Comment for planning application 6/2021/0773/FULL

| Location | 1 Maynard Place Cuffley Potters Bar EN6 4JA |
| Proposal | The erection of a one storey roof extension to create 6 no. flats including 3 x 1 bed and 3 x 2 bed flats, with associated parking and cycle and refuse provision |
| Type of Comment | Objection |

DRAWING TITLE:
Proposed Ground Floor Plan

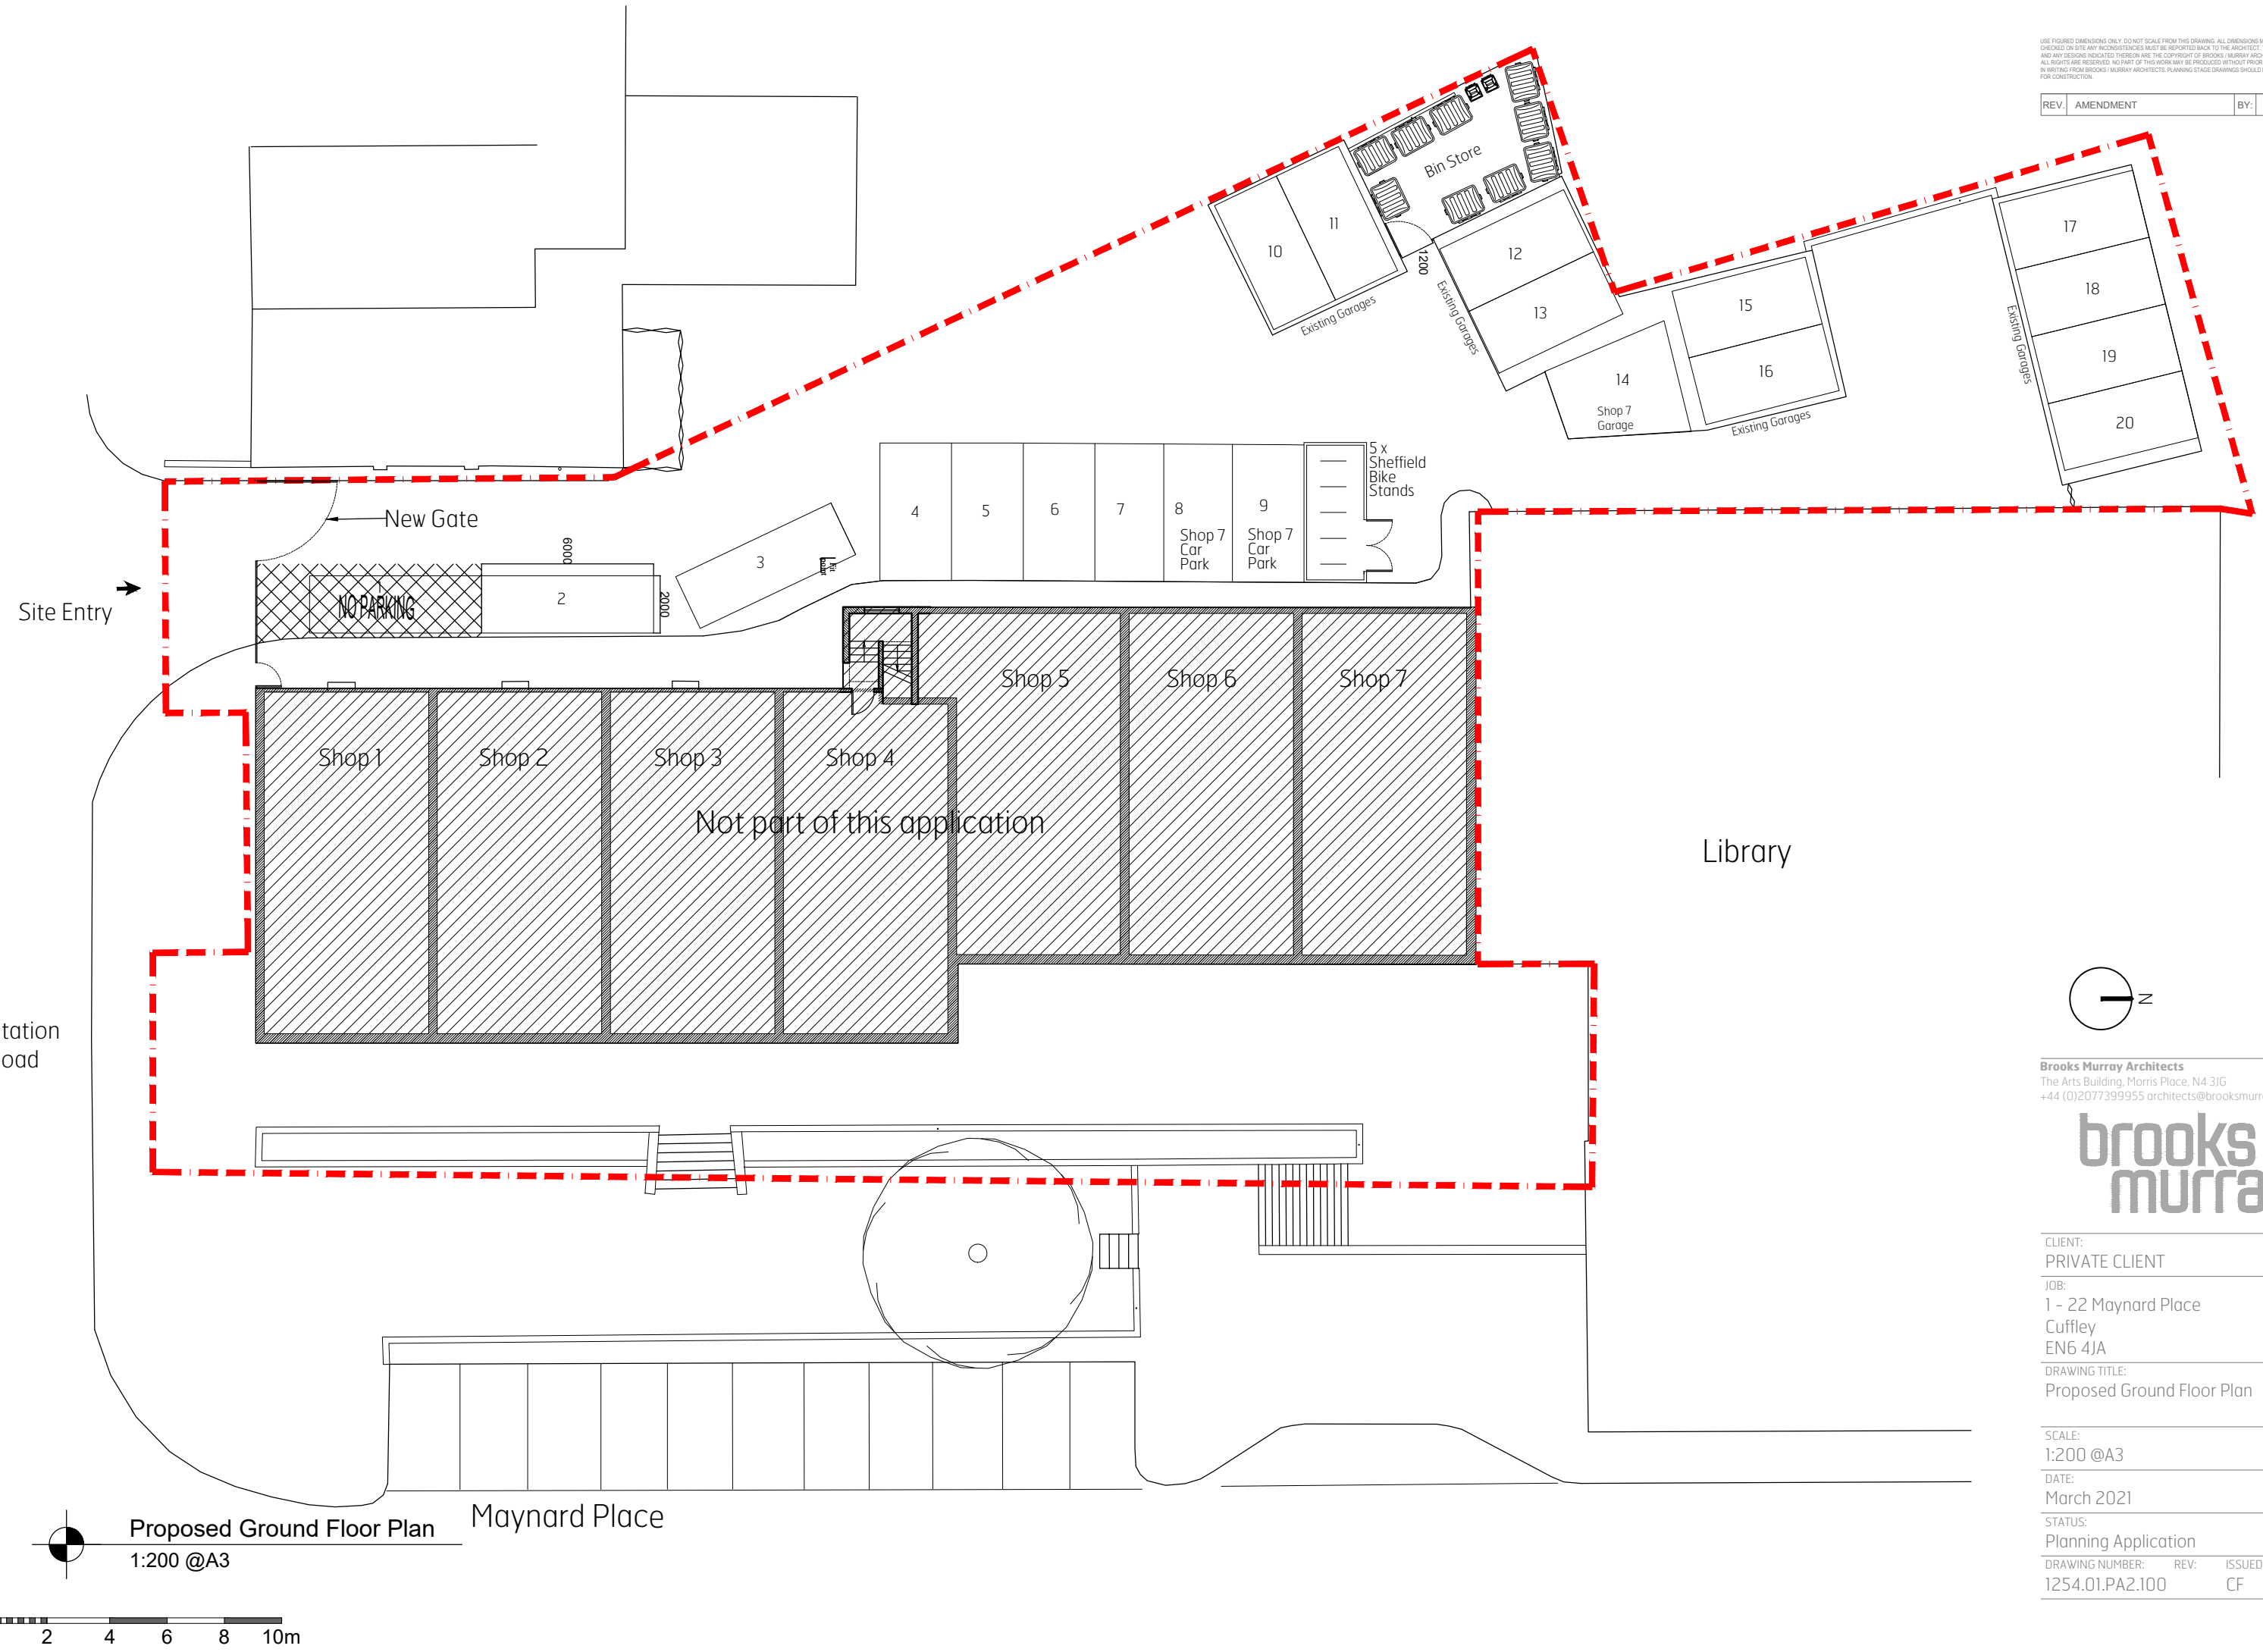
| Comments | <p>The parking issue will be worsen & be a bigger problem and although there may not technically be "under provision", the scheme will still impact on the wider area and the car park will become impossible to manoeuvre around. The council seems to not be aware that garages have been sold off which is a real issue on a daily basis without additional flats. Reduced space for deliveries will be problematic The scheme remains extremely undesirable and adds to car parking pressure in the area. It is over development of the site and would lead to loss of residential amenity for occupiers of the flats in terms of difficulty in parking. There will be a traffic flow problem on the main road as cars try to enter the car park with a gate in place, No consideration to subsidence in the area and the basic foundations not being suitable for another layer of accommodation Loss of light & additional noise will be created - purchase of top floor flat was to avoid anyone living above Totally object</p> |
